Ribble Valley Borough Council
Housing & Development Control

Application no: **3/2023/0546**

Address: **65 Mitton Road Whalley BB7 9RY**

Proposal: **Demolition of existing single-storey side and rear extensions, and construction of two-storey extension to the side and single-storey extension to the rear.**

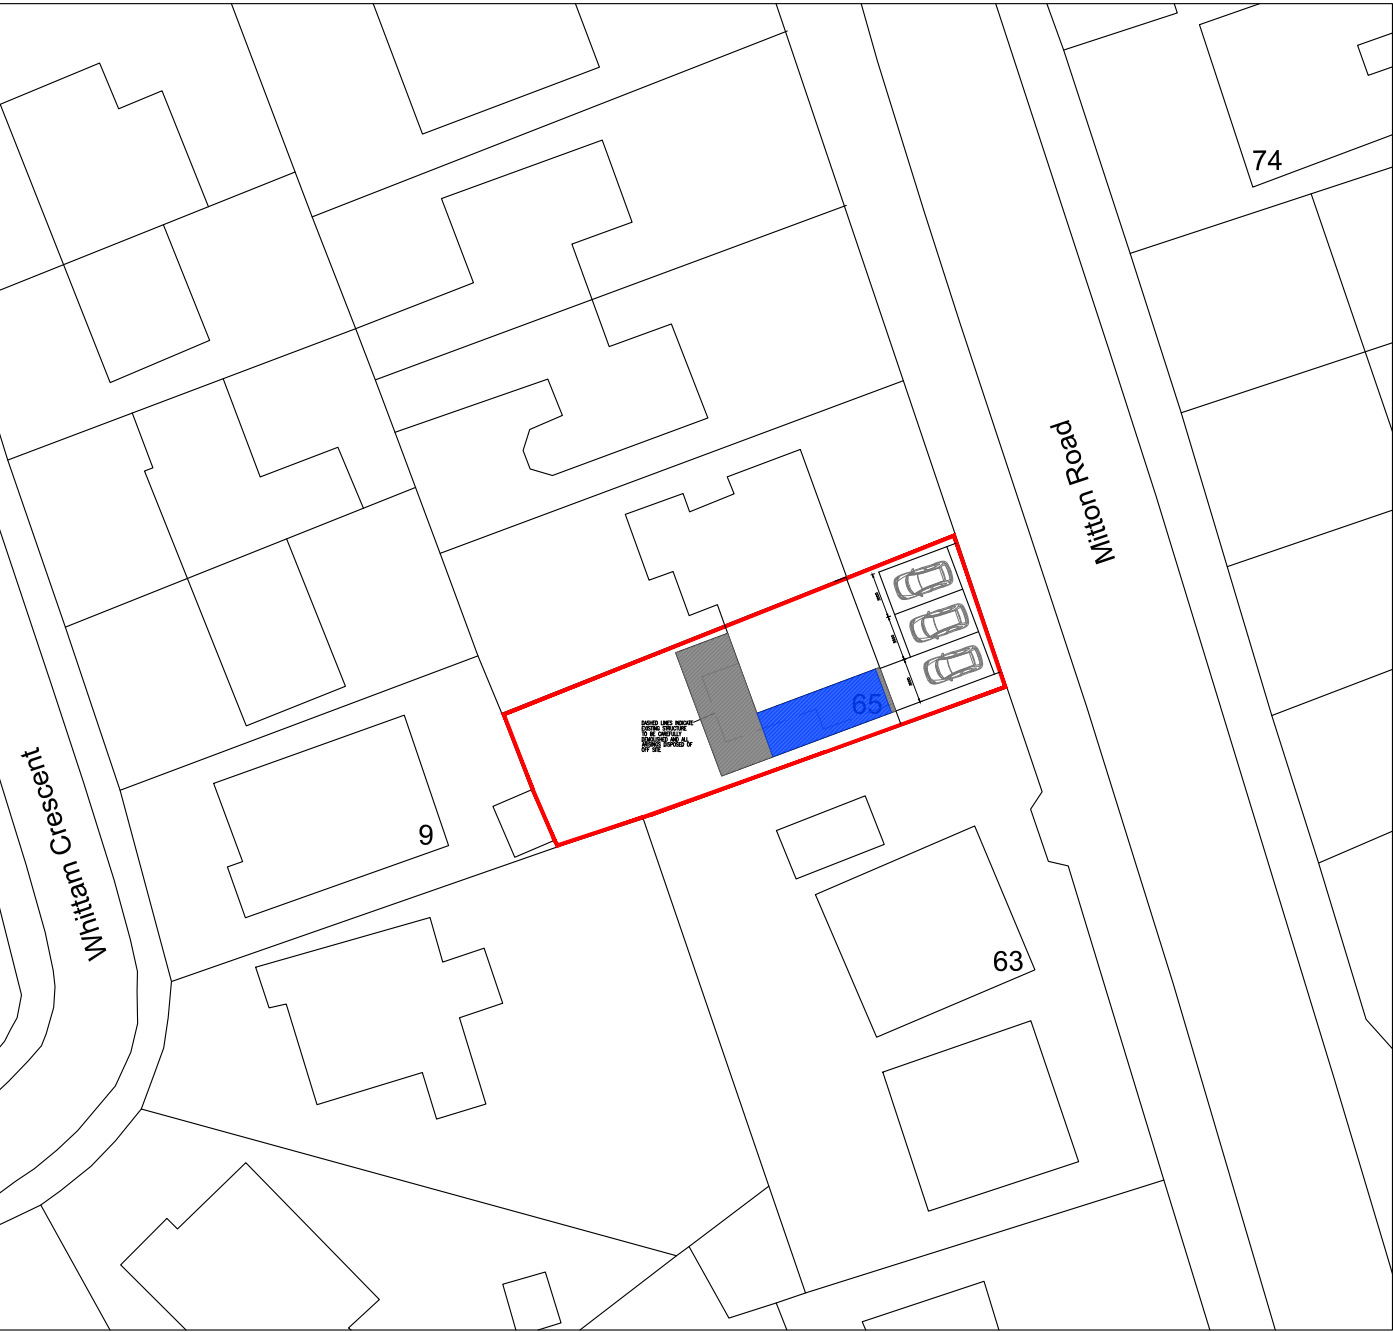
To ensure that the garage can provide a car parking space, the LHA require the internal dimensions of the garage to be widened to 3m and the existing access and driveway should also be extended by a further 2.4m to provide an additional car parking space and provide 3 spaces in total to comply with the LHAs guidance. These changes should be shown on an amended plan.

Rev.	Description	By	Date
Project Mr. Discretion 65, Mitton Road Whalley, Clitheroe Lancashire BB7 9RY		Drawing Title Proposed Layouts Drawing No. Wilson/02	
		Rev. B	
Drawn by Scale P.E. 1:50@A1		Date May '23

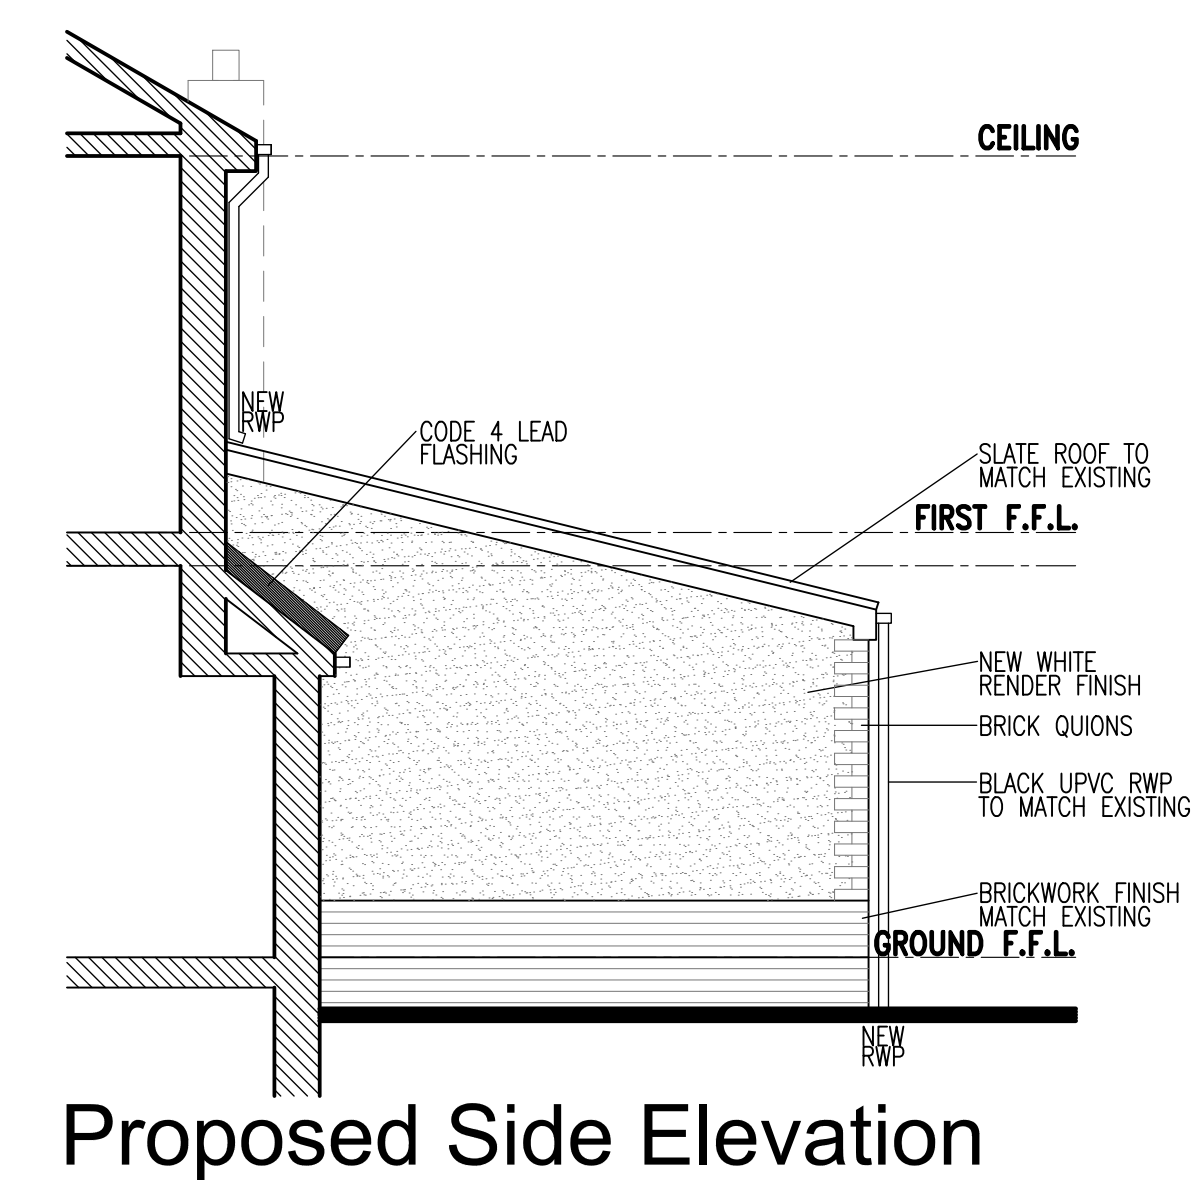
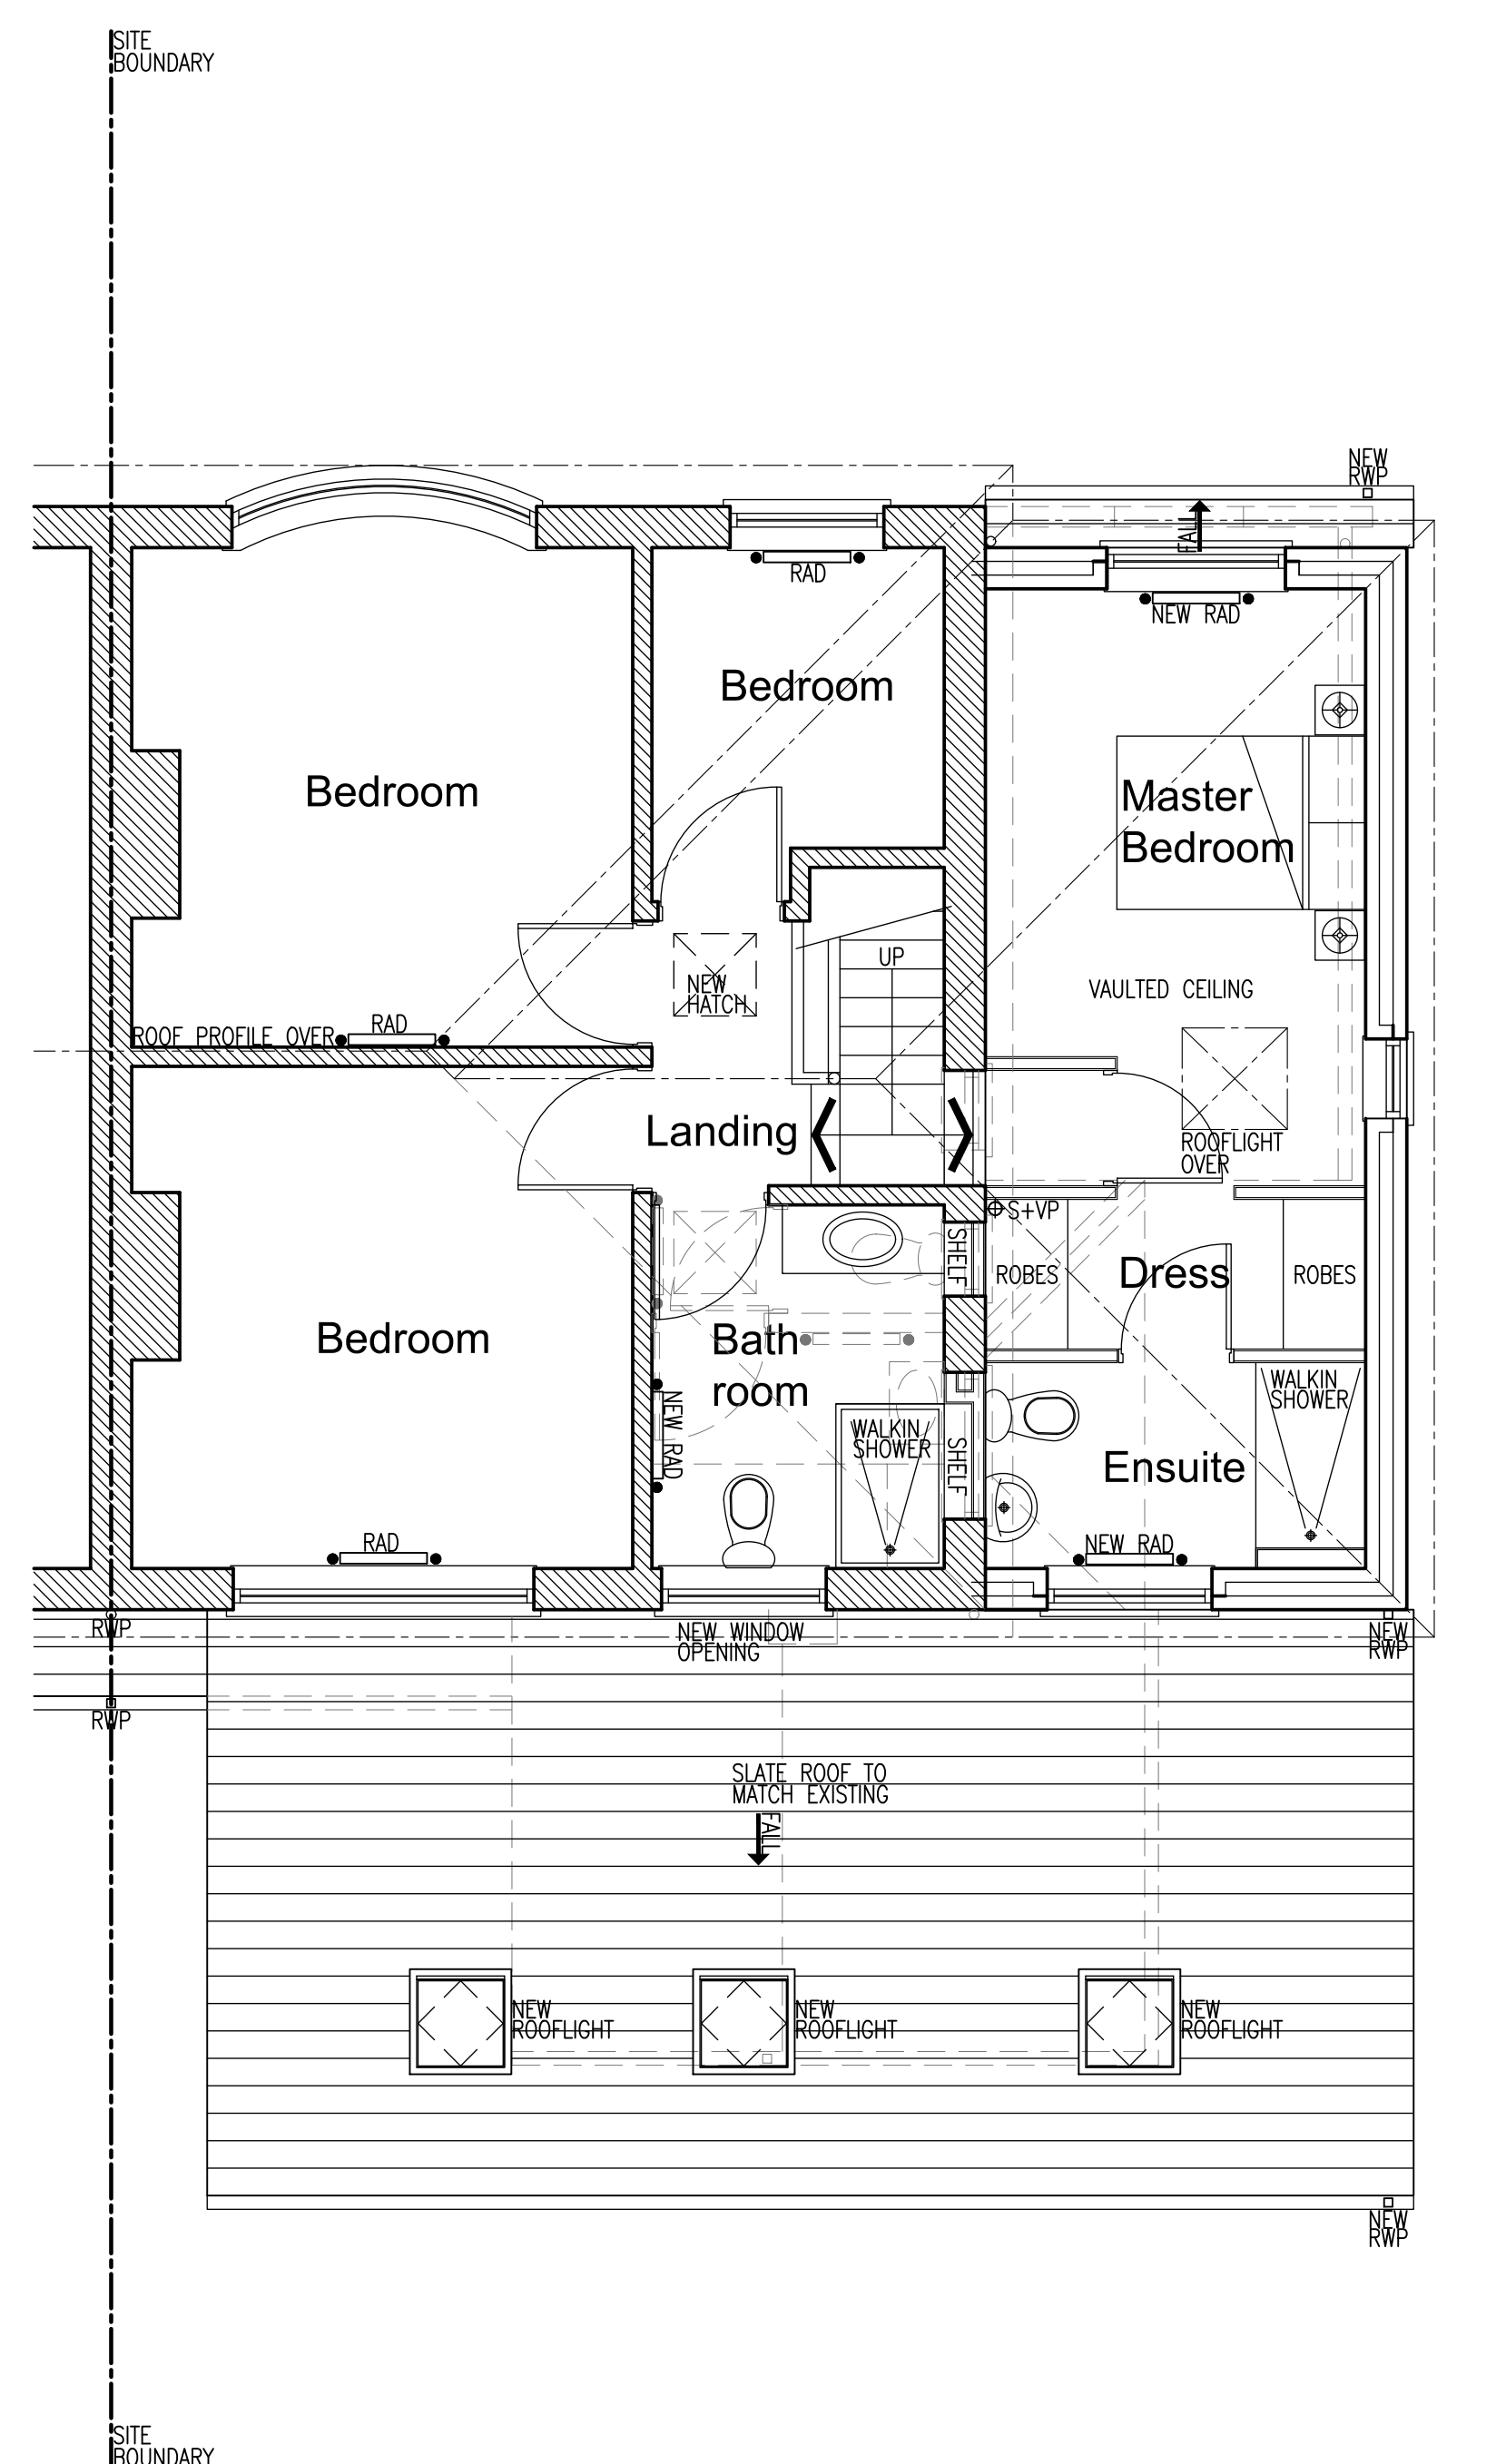
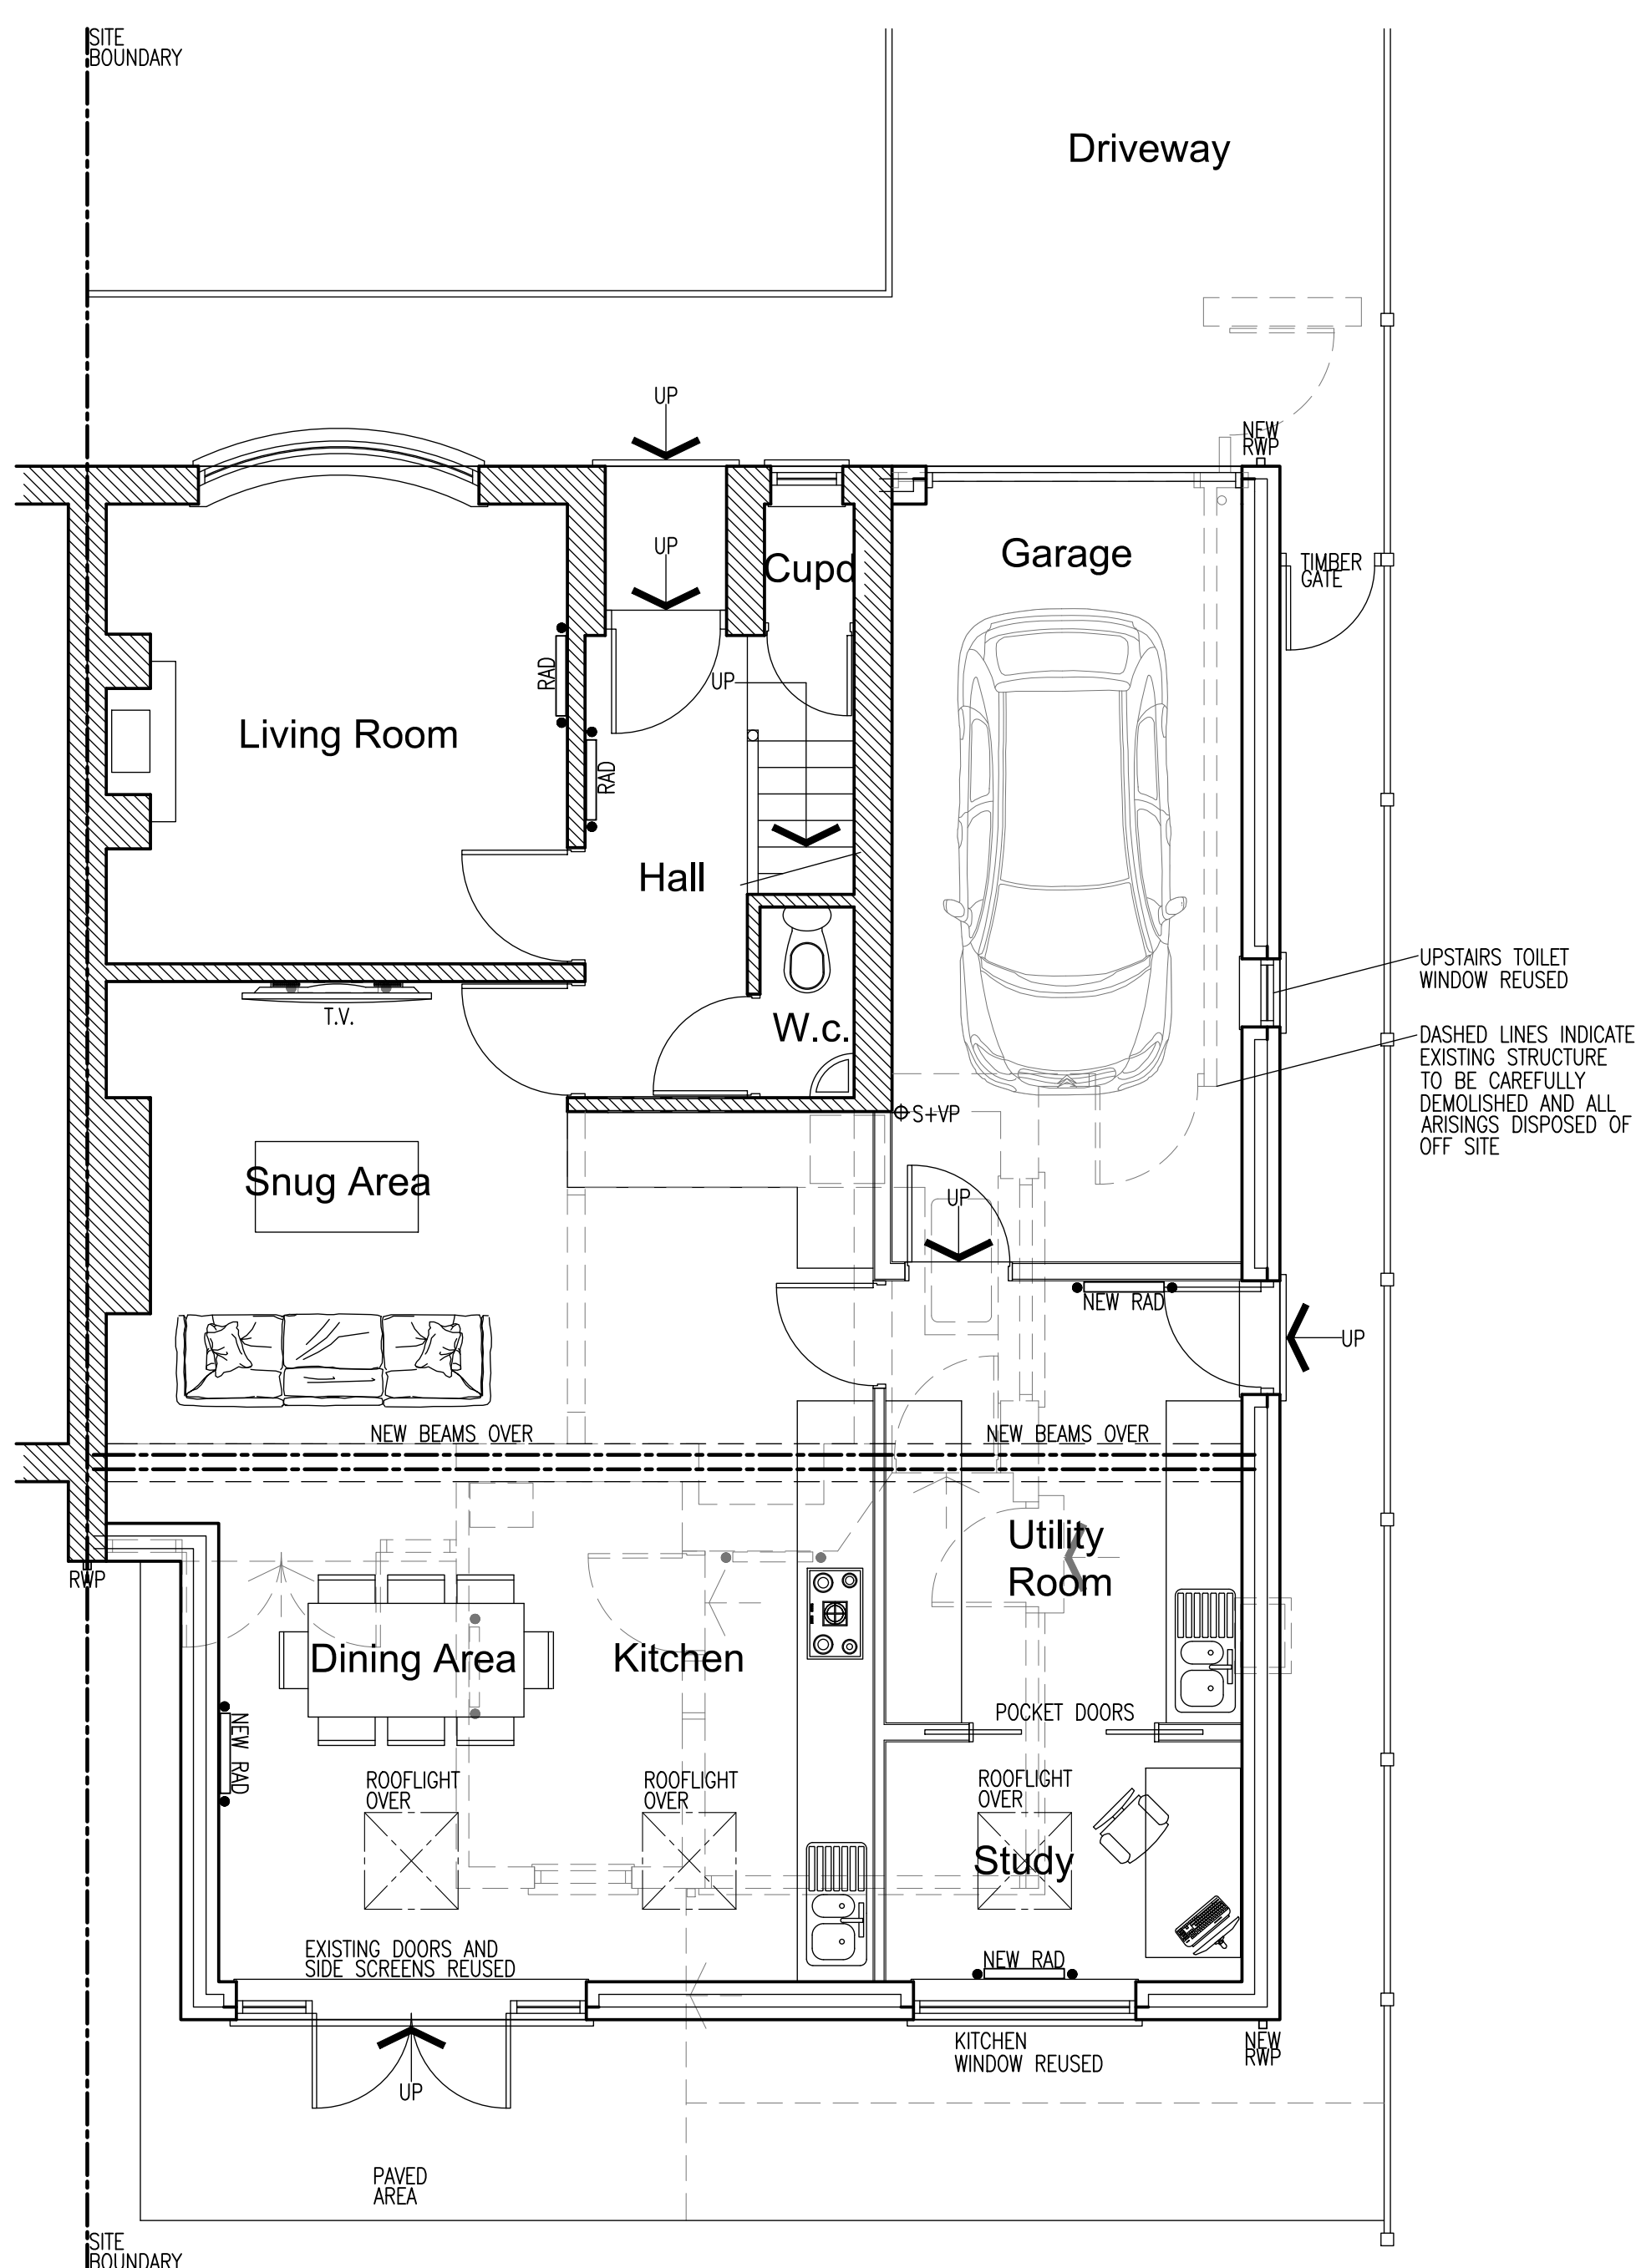
The LHA have reviewed drawing number Wilson/02 Rev A titled "Proposed Layouts" and are aware that the number of bedrooms at the dwelling will increase from 3 to 4. For the dwelling to comply with the LHAs parking guidance as defined in the Joint Lancashire Structure Plan, the LHA require the dwelling to provide 3 car parking spaces.

However, the LHA have reviewed the supporting documents and are aware that the dwelling can only provide one car parking space which fully complies with the LHAs guidance. This is because, while the LHA welcome the extension to the existing integral garage, with the internal dimensions being 2.7m wide by 6.2m in length, the garage still does not comply with the LHAs guidance when providing a car parking space. Therefore, there is a shortfall of two car parking spaces.
